Planning Application: Seeking advice on an **OUTLINE** planning application for the construction of 57 dwellings on a field at the end of Orchard gardens, Woodgate.

Reference: AL/111/16/OUT

Location: Land east of Orchard Gardens, Woodgate,

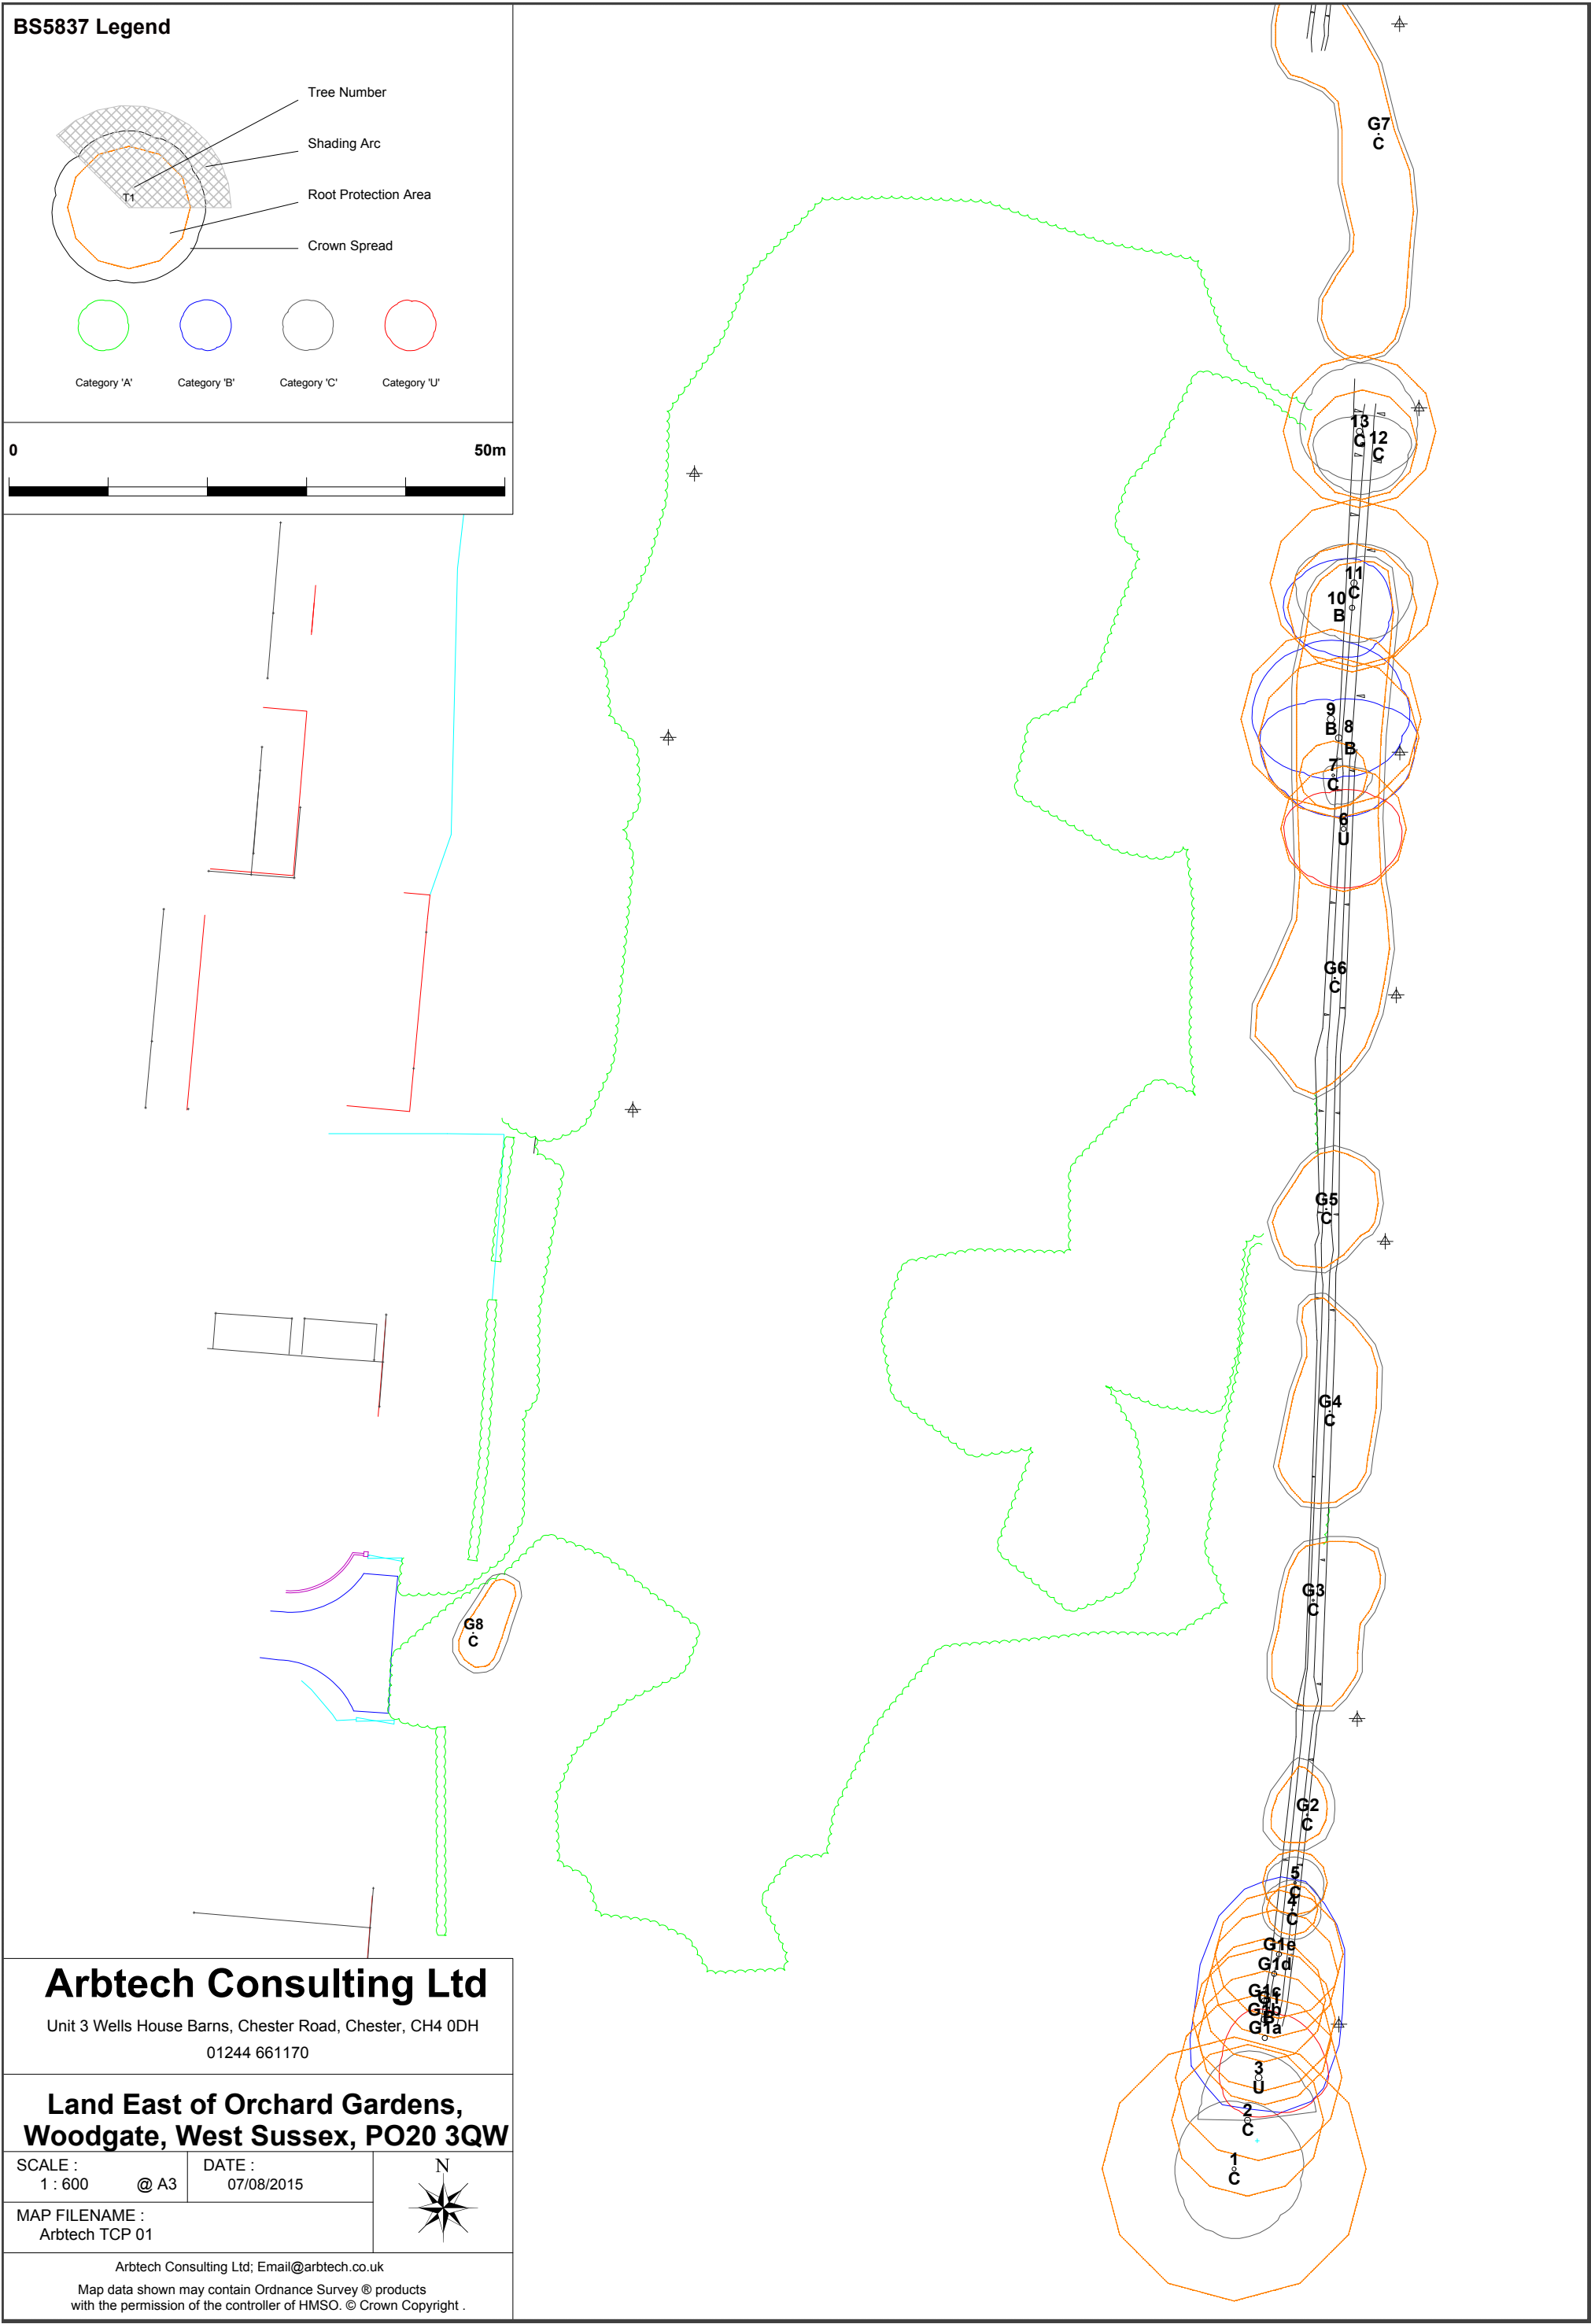
Comments: From my site visit and study of the submitted plans I am generally comfortable with the level of arboricultural information which has been submitted to date – which is a Tree Survey by Arbtech which complies with BS5837 requirements and a topographical plan with trees accurately plotted onto it and Root Protection Areas also plotted – thus we have a Tree Survey & Tree Constraints Plan. Although in the case of some of the Oaks assessed as having only 20-40 years remaining life I would take issue as these are clearly tree that will last beyond 40 years – however I do agree with the B gradings.

- Sufficient arboricultural information has been submitted with this OUTLINE application in order to assess the likely impact on the tree stock.
- It is probable that the group of Ash Trees 1, 2 & 3 would need to be removed for safety reasons due to their poor condition – I would not want them to be retained anyway with this layout as they would overshadow and dominate the rear gardens of Plots 36 & 37 and cast significant shade and place owners at risk given that the new houses would be in the fall zone of these trees.
- I am satisfied that Oaks 8, 9 & 10 are shown to be adjacent to an open space area and not near any dwellings where conflict might ensue.

- As it stands I would see no reason to object to these proposals on arboricultural grounds.
- However, if this comes back in as a full and detailed application I would expect to see it supported by an **Arboricultural Impact Assessment & Method Statement Report** inclusive of a **Tree Protection Plan** defining which trees are to be retained and which trees are to be removed and how they would propose to protect the retained trees and if necessary mitigate any adverse impact on the root systems of these trees – thus complying with the recommendations of BS5837:2012 – Trees In Relation to Construction.
